Donna M. Palmer B. Bus, CPA, MACS.
Quality Assurance Specialist (Retired)

Re: Submission to exhibition of SSD-82709458 at 19-25 Balfour Street, Lindfield

Drawn:
**OVERSHADOWING DIAGRAMS
(PROPOSED)**

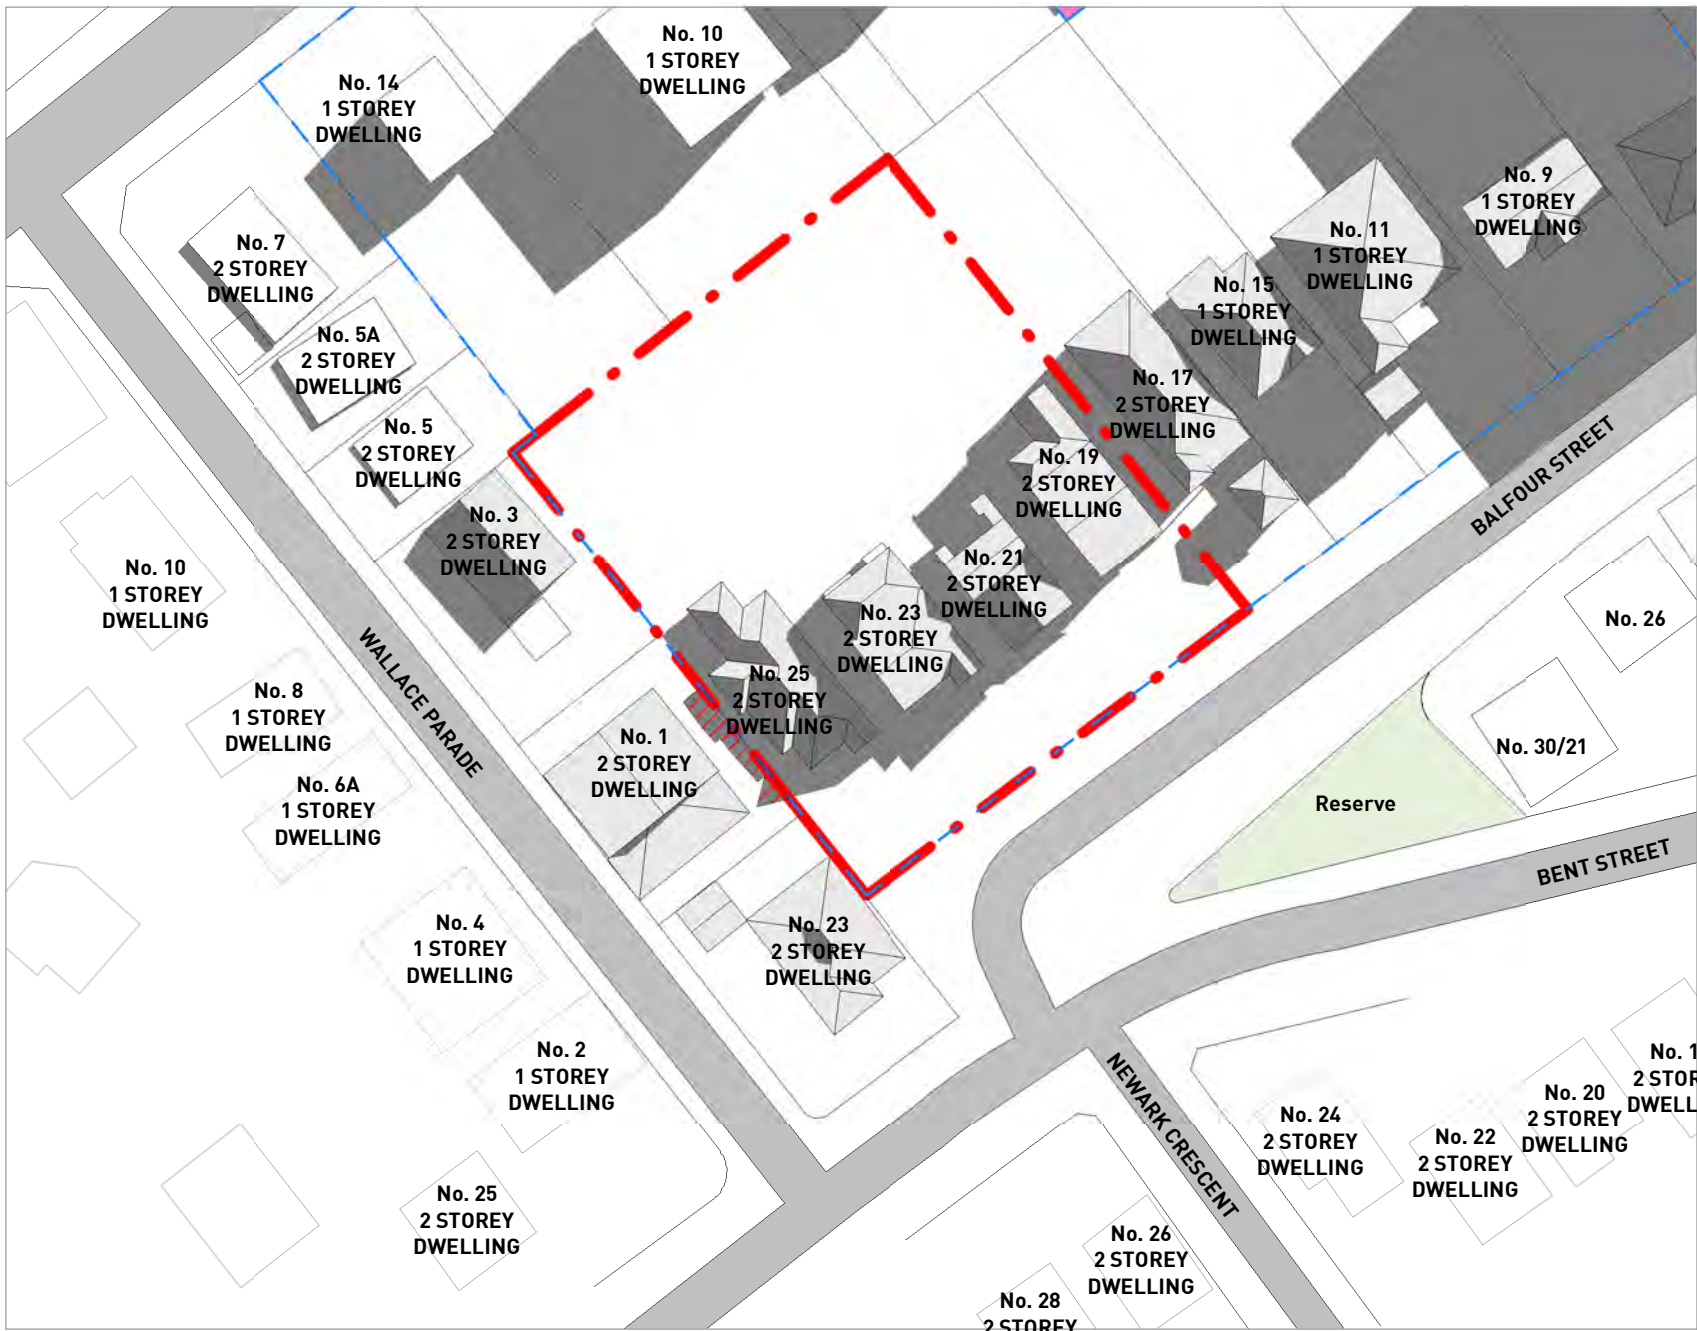
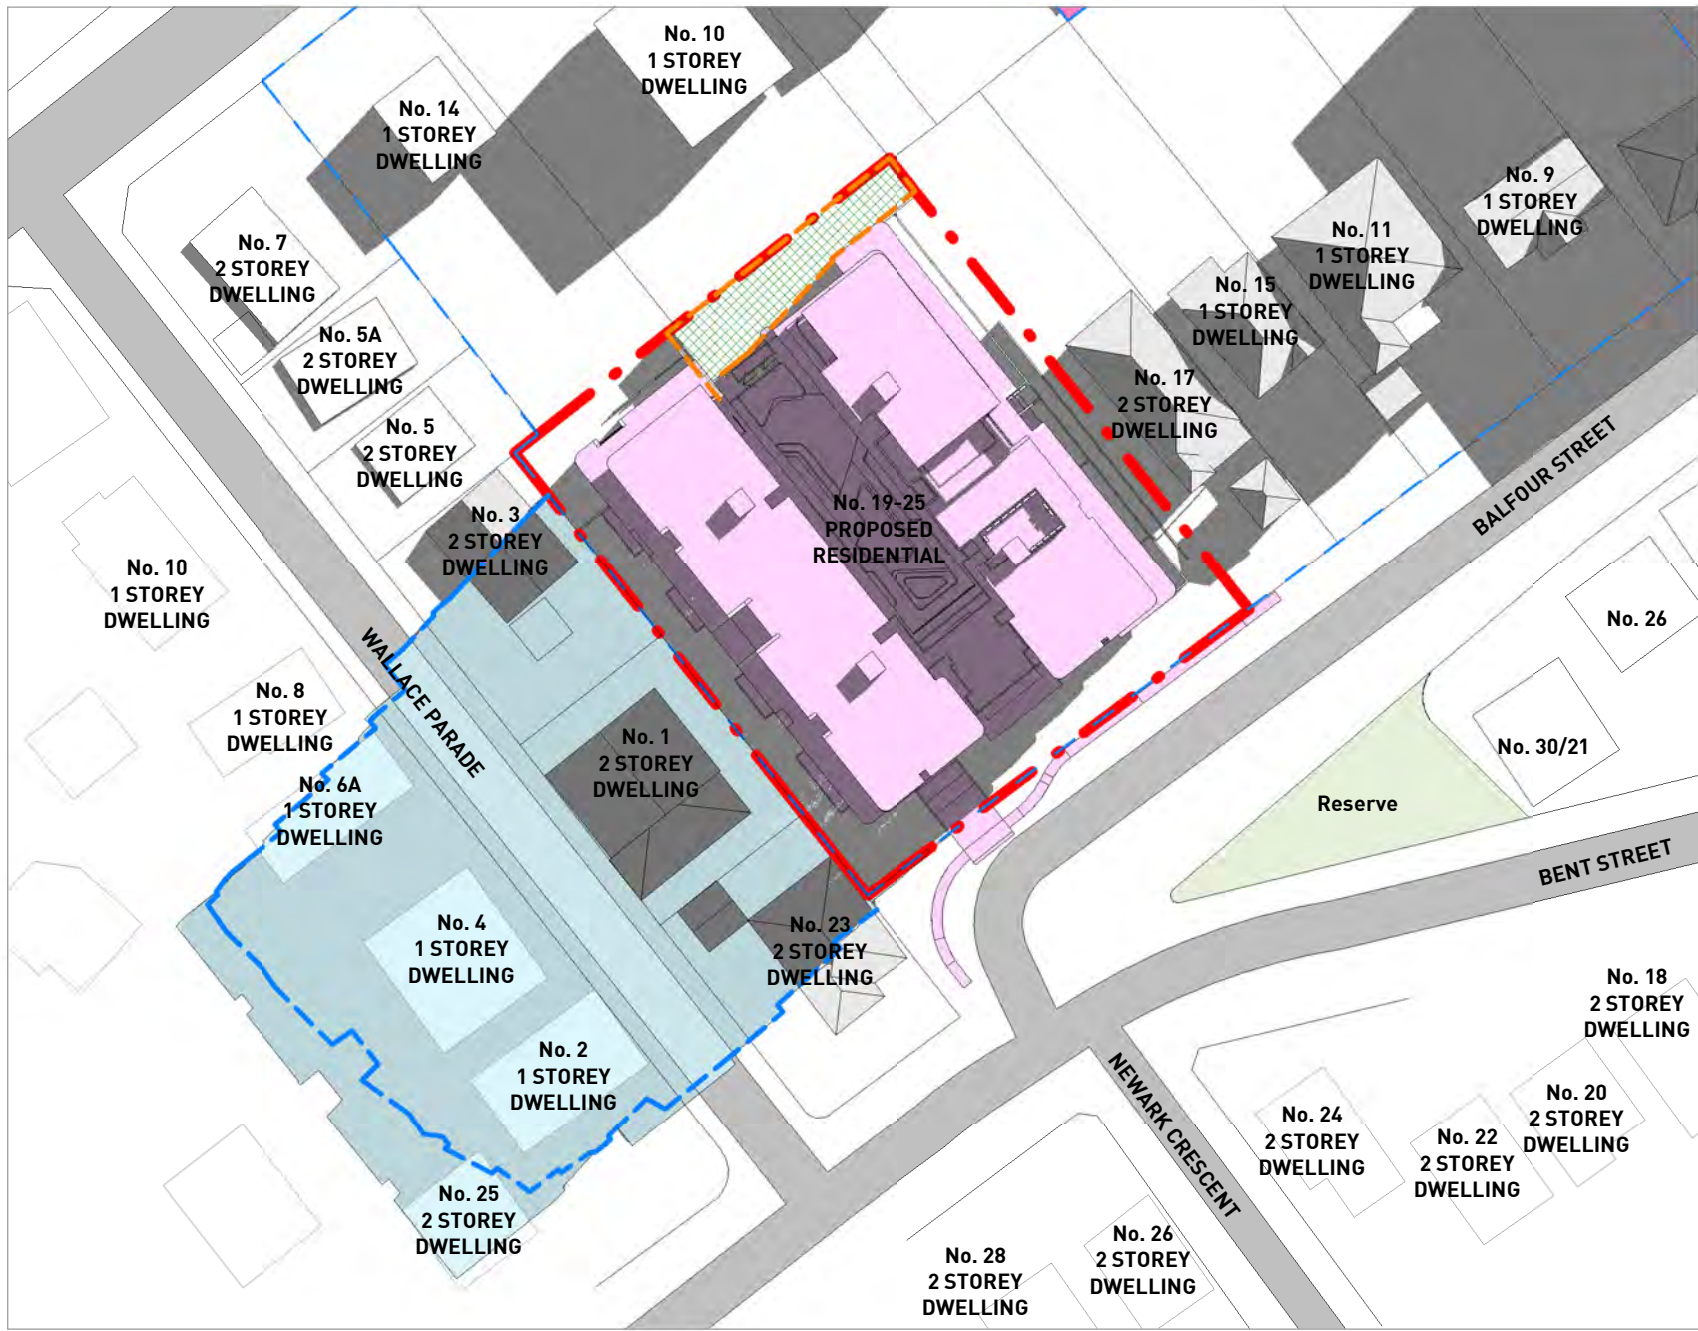
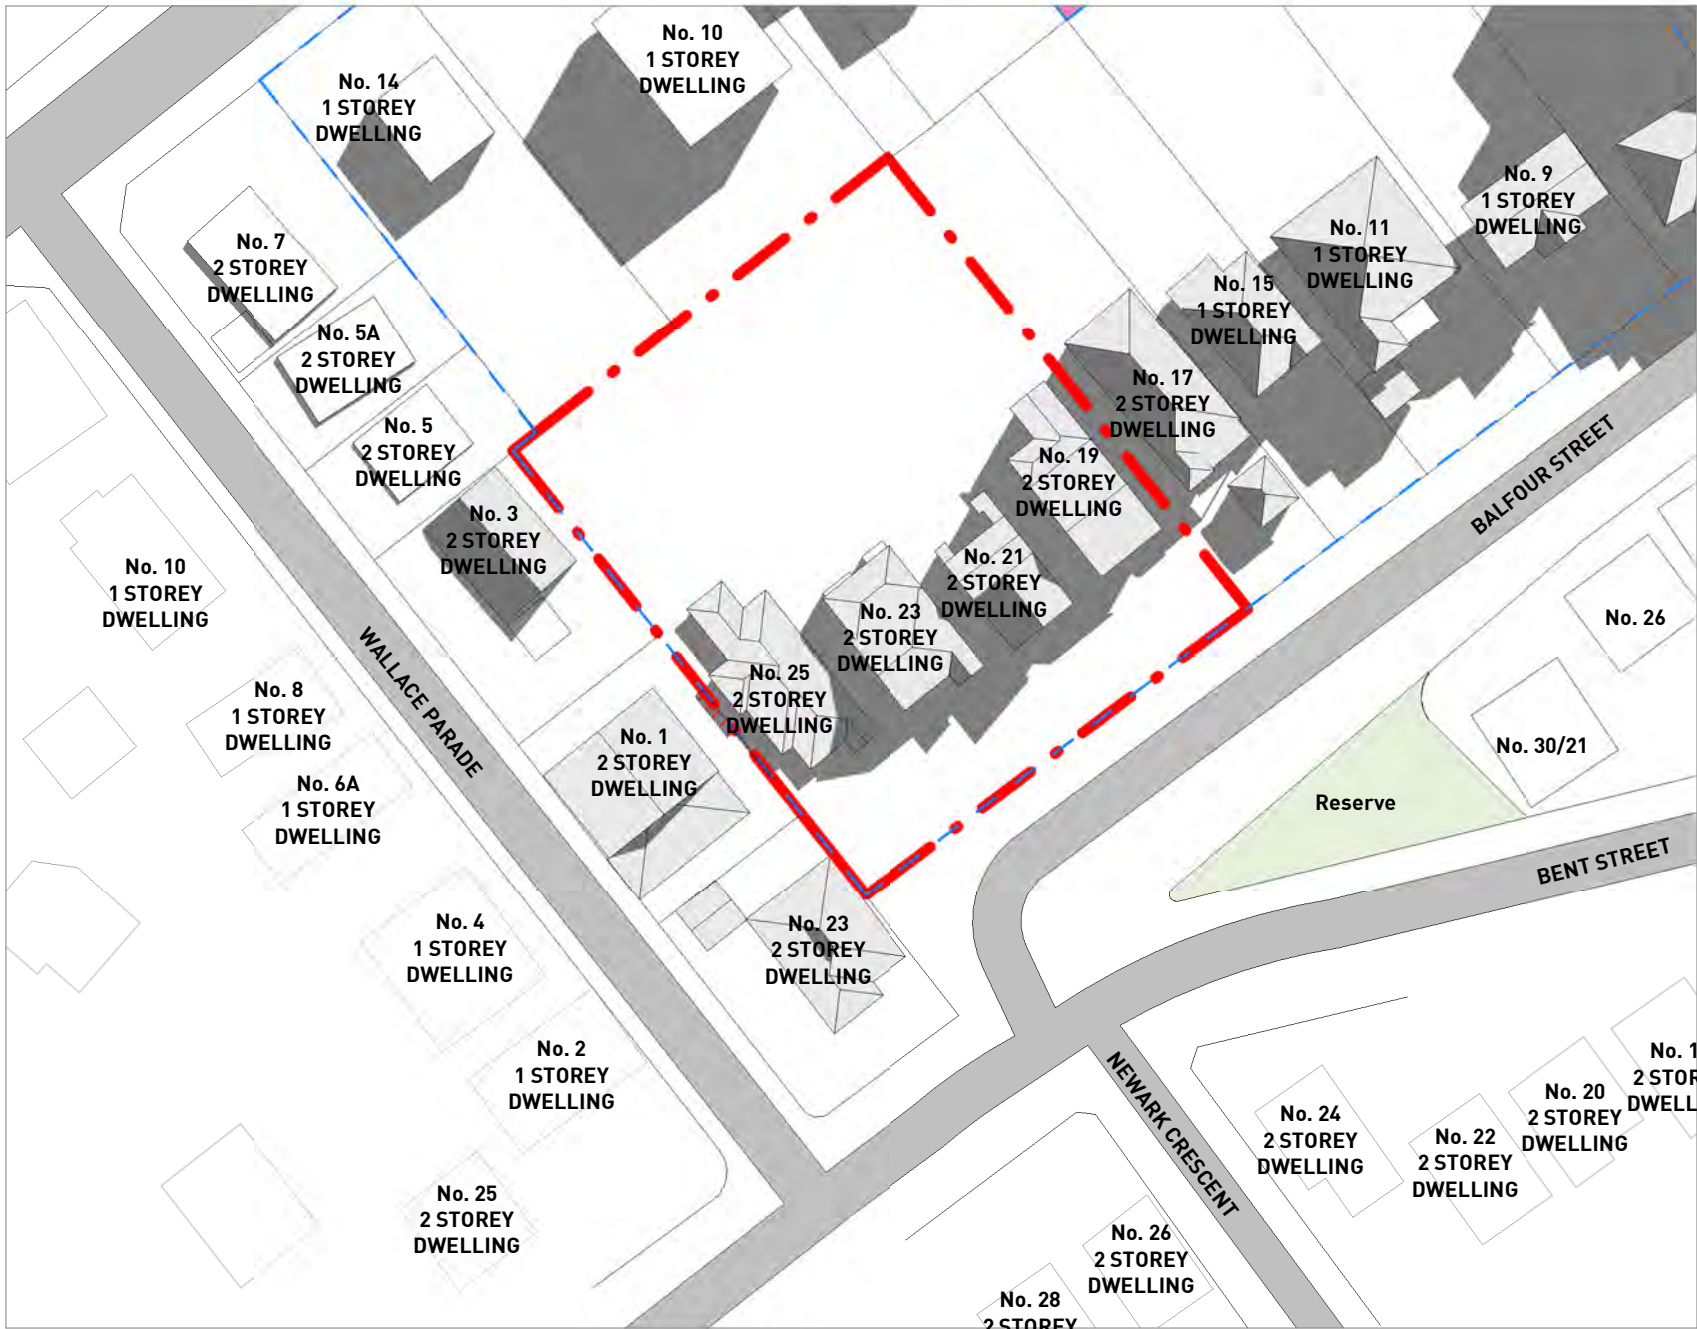
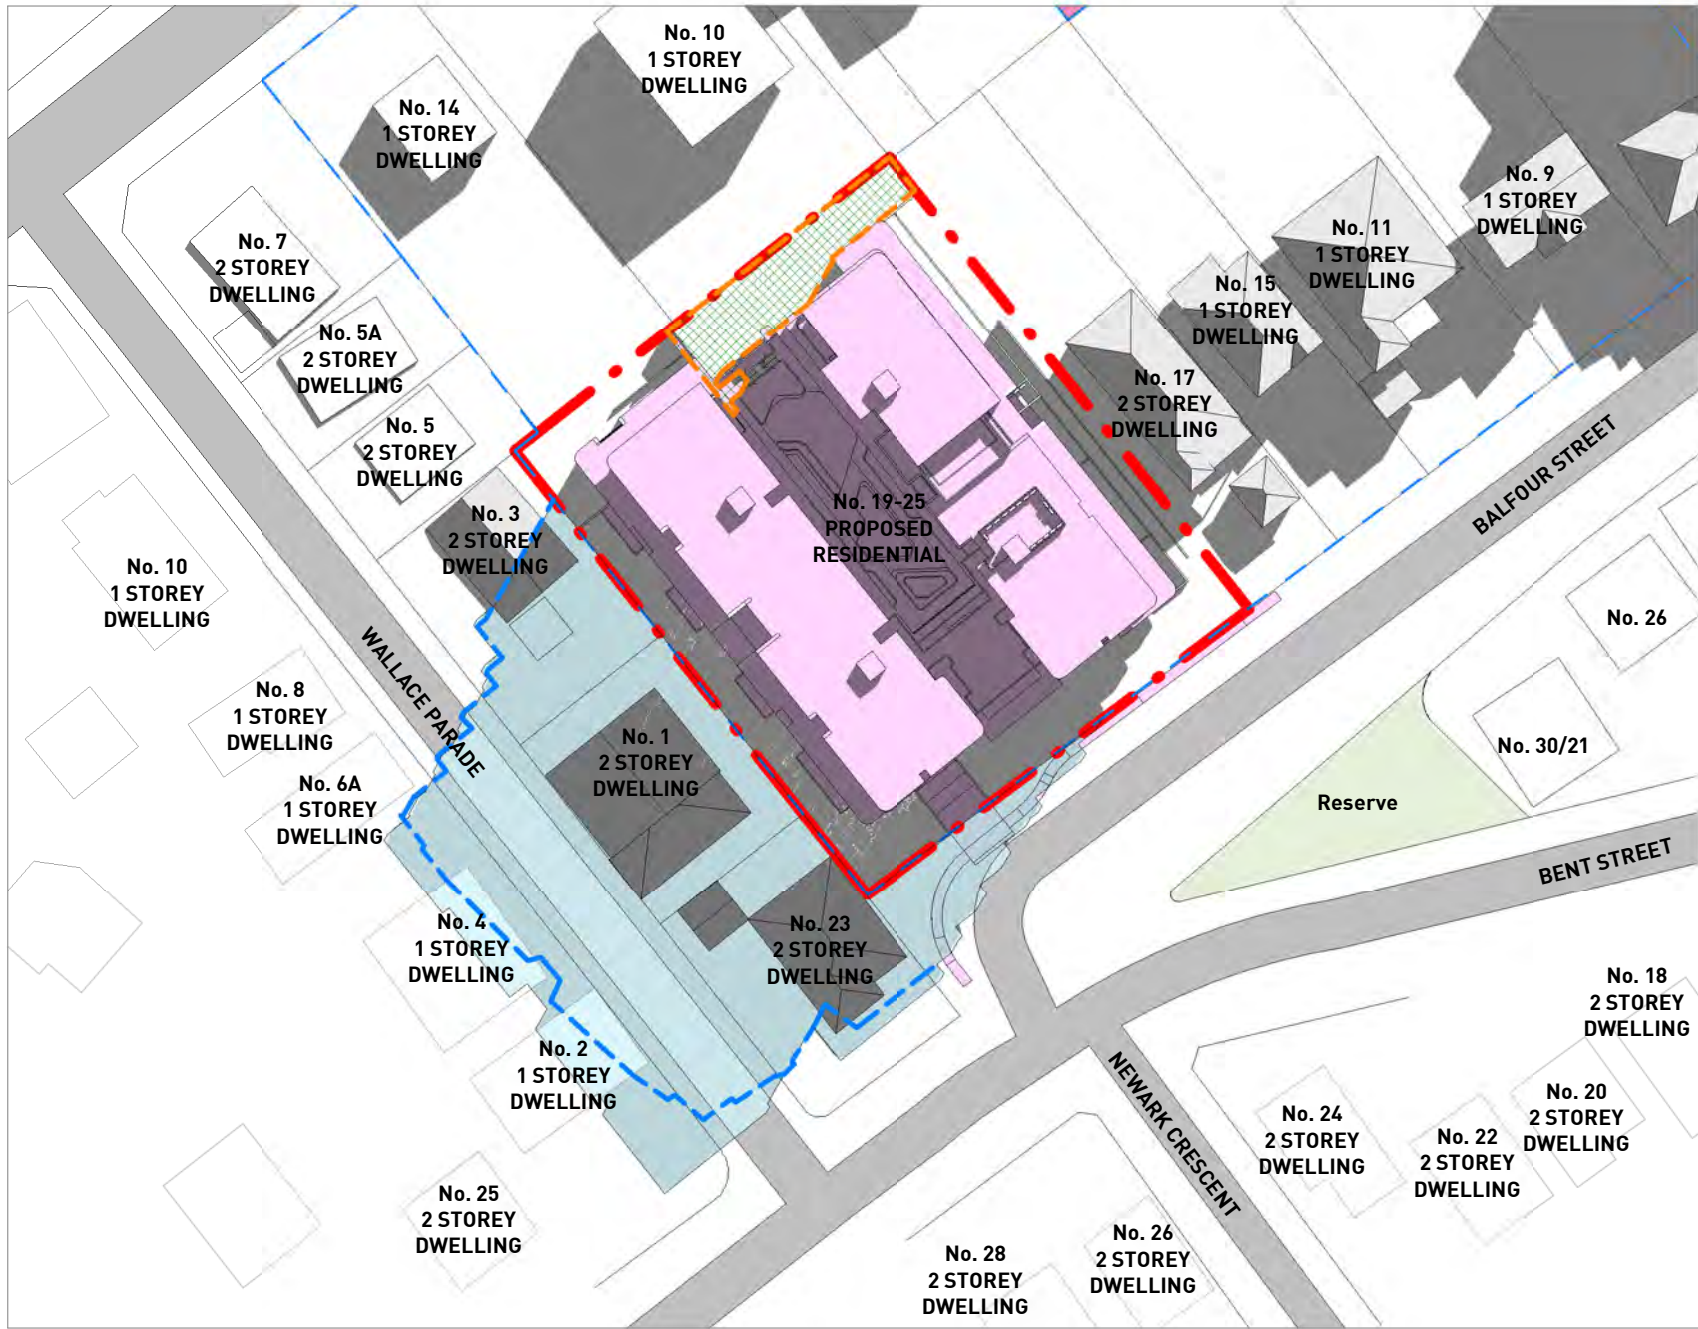
The morning shadow diagrams that would affect 14 Highfield Road have not been drawn at all. It is clear that the morning sun will not reach our yard, especially during winter and will affect the many plants we have and will also detrimentally affect my bird aviary which is located at the back of my property near number 23 Balfour Street and currently gets filtered sunlight.
